From: Bloomer, David <David.Bloomer@lancashire.gov.uk>
Sent: 15 September 2017 10:40
To: Robert Major
Cc: LHS Customer Service; planning
Subject: app3/2017/0772 20 Abbey Fields , Whalley

Dave Bloomer
Highways Development Control
Lancashire County Council

320170772P		
Peter Hitchen Architects		
Project: PROPOSED NEW DWELLING, 20 ABBEYFIELDS, WHALLEY BB7 9RS		
Client: MR & MRS KNOWLES		
drawing title: PROPOSED SITE PLAN		
Scale: 1:100 @ A2		
Drawn by: DS	checked: PH	
Date: 04 / 09 / 17		
project no. PHA/072	dra. no. 200	rev. A

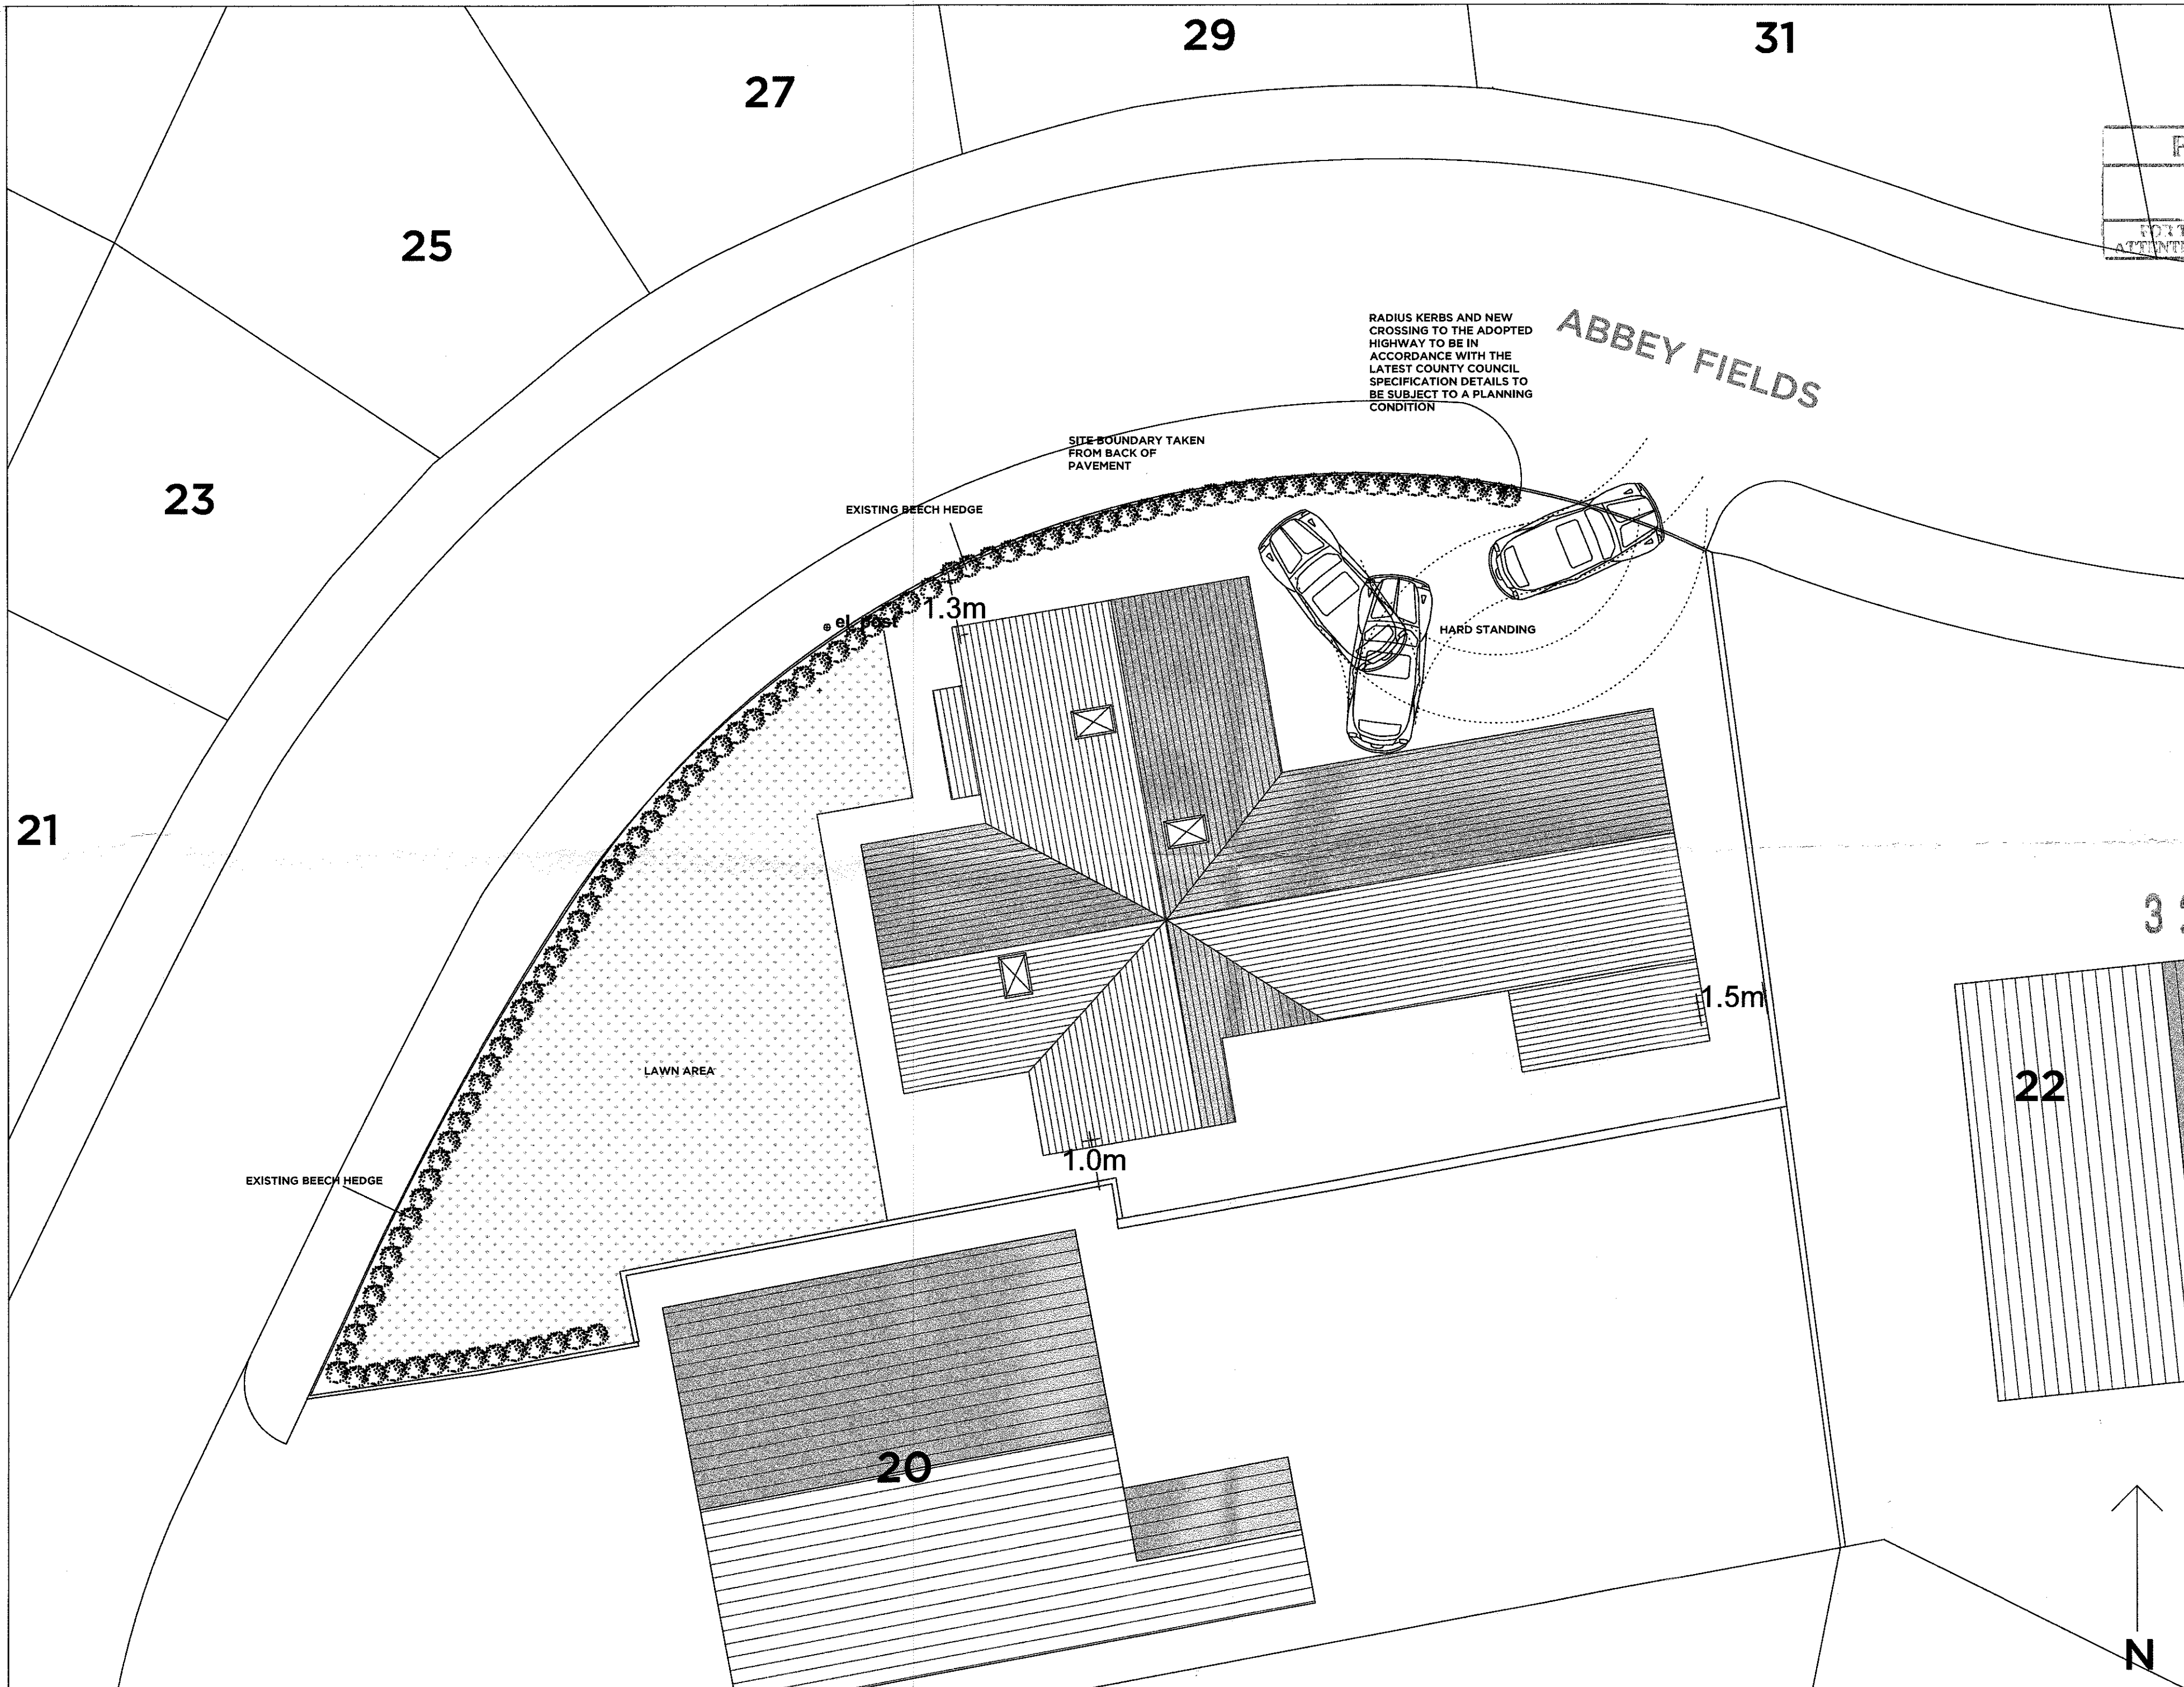
The access has a poor visibility to the left on exit (2m x 7m to nearside kerb) Bearing in mind the prevailing 20mph speed limit the appropriate visibility should be 25m however the achievement of this is obstructed by both the beech hedge and the proposed building. I would also be concerned that the manoeuvring in the parking area is restricted and would need to be reviewed.

On the basis of these comments I would have to recommend that the application be refused on the grounds of poor visibility resulting in a potential road safety hazard to road users
